**Consultation Response from KC,
Highways Development Management****2025/92267 adj, 37, Lingards Road, Slaithwaite, Huddersfield, HD7 5HY****Demolition of existing garages and erection of 3 dwellings****Date Responded: 18/12/2025****Responding Officer: D. Stainsby****Responding Ref: K1-32/20**

This application is for the demolition of existing garages and the erection of 3 dwellings.

Proposed site plan (1:500).

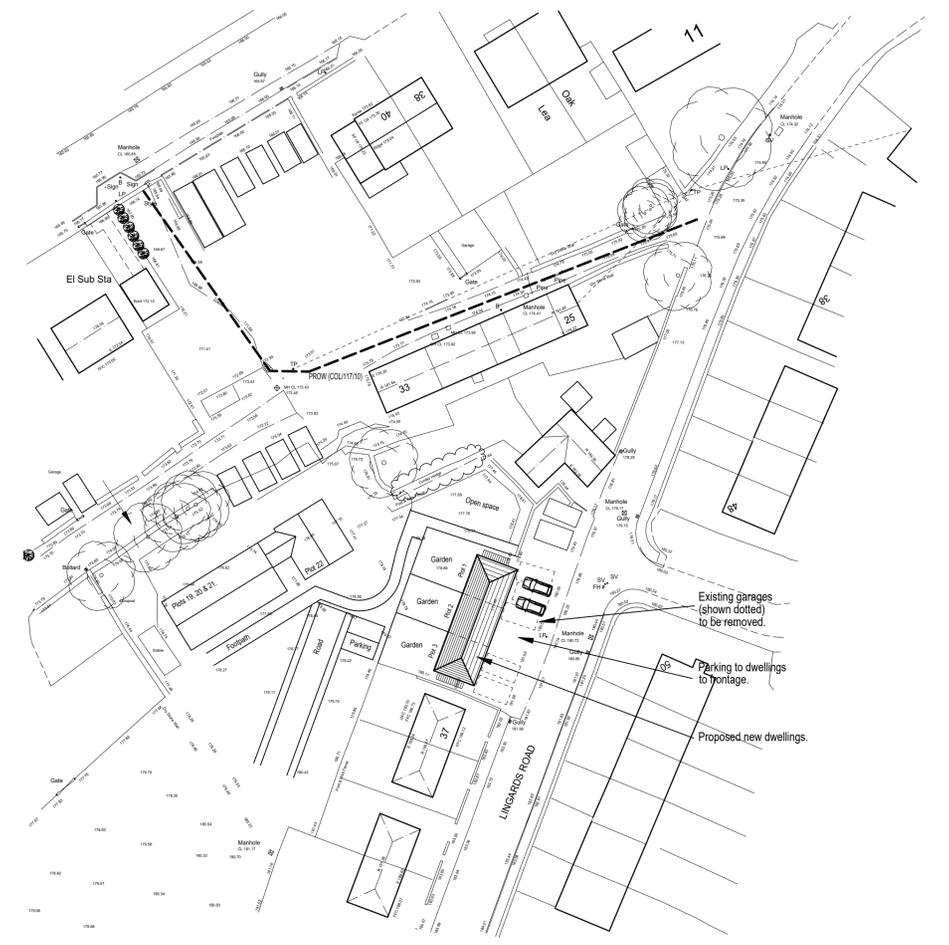
Vehicular and pedestrian access is proposed directly from Lingards Road. However, there is currently no footway along the frontage of the site.

To ensure the safety of pedestrians accessing the proposed dwellings it is considered that a 2m wide footway should be provided along the site frontage. The footway should tie into the existing footway which currently terminates outside No 37 Lingards Road.

There is an existing lamp column on the site frontage, and this may require relocating as part of the proposals.

No details have been provided on waste storage.

Details of waste storage and collection should be provided, with the location of a waste collection presentation point being clearly marked on a drawing in such a location that is easily accessible to the collection team and where it will not obstruct the parking, access or the adopted highway for road safety reasons.

Development shall not commence until a detailed scheme for the provision of a minimum 2.0m wide footway to the full site frontage has been submitted to and approved in writing by the Local Planning Authority. The scheme shall include construction specifications, white lining, signing and surface finishes. The approved scheme shall be completed before the occupation of the first dwelling on site and retained thereafter.
